CITY OF ALBUQUERQUE

May 20, 2022

**Re: Valley View
9368 Valley View Drive NW
Traffic Circulation Layout
Architect's Stamp 05-17-2022 (C13-D036)**

1 Site Plan - Proposed
Scale: 1" = 20'-0"

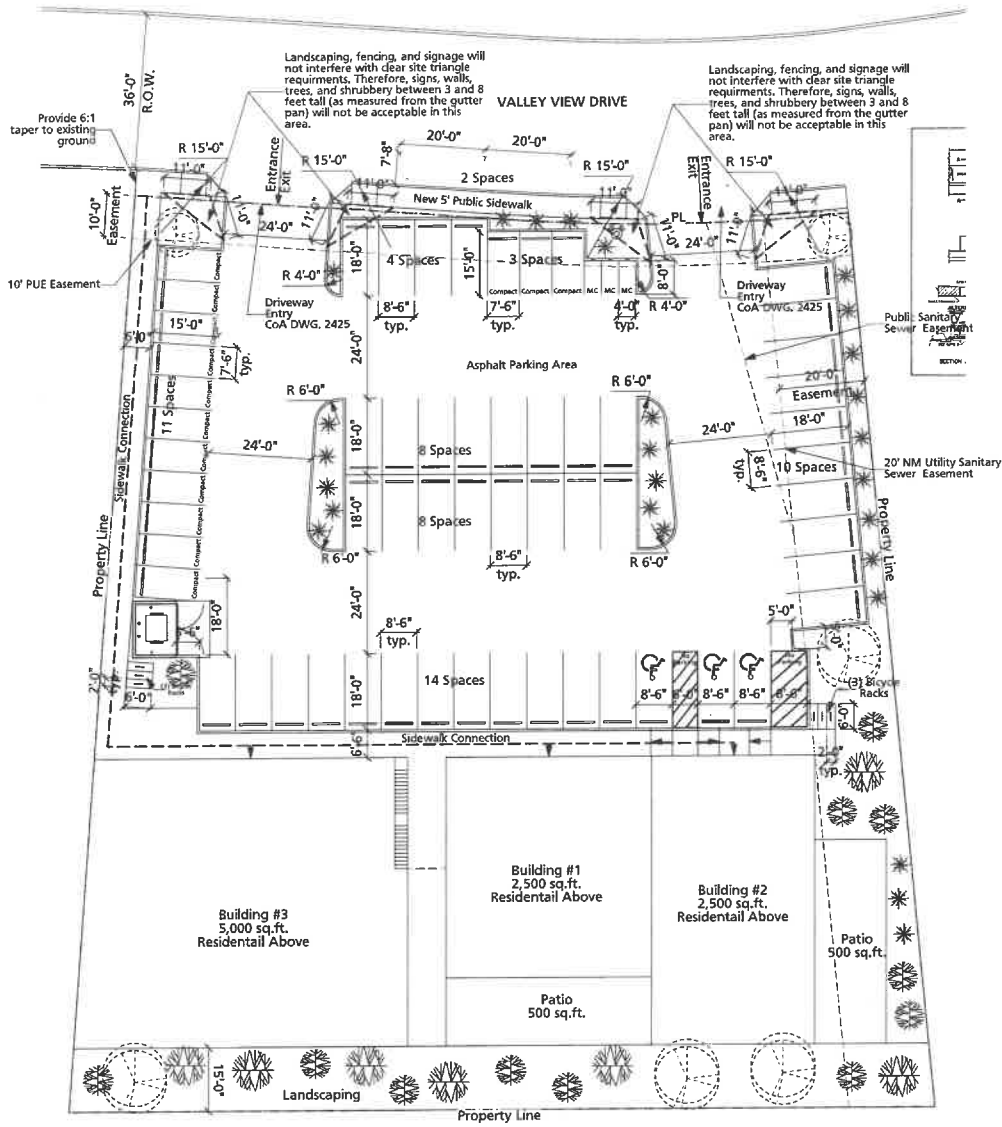
- PO Box 1293
- Albuquerque
- NM 87103
- www.cabq.gov
1. Please provide the location of property line and label it because it is not apparent.
 2. The proposed 6 ft sidewalk and driveway ramp are in conflict. Please clear this safety concern.

3. The two 5' radii's around the Gym parameter will need to be 15'R.
 4. **Keyed Note 3:** Does the note need to be applied to the western portion of sidewalk shown adjacent to proposed driveway?

5. **Add note to eastern portion of proposed sidewalk:** 'Provide 6:1 taper to existing grade.
 6. **Keyed Note 13:** Specify the the color WHITE on text for proposed parking stripe on cross walk striping.

7. **Motorcycle parking spaces:** Label pavement MC and provide text detail.
 8. ADA accessible pedestrian pathway should not be placed behind parking space and/or between them and adjacent to a vehicular way. Vehicle and pedestrian/wheel chair conflicts should be avoided as much as possible. **Provide shielding/curbing between parking stalls connecting into Unit complex.**

9. The 6ft sidewalk pathway adjacent to complex sidewalk will need a ramp to connect to each other.
 10. Please provide a letter of response for all comments given.
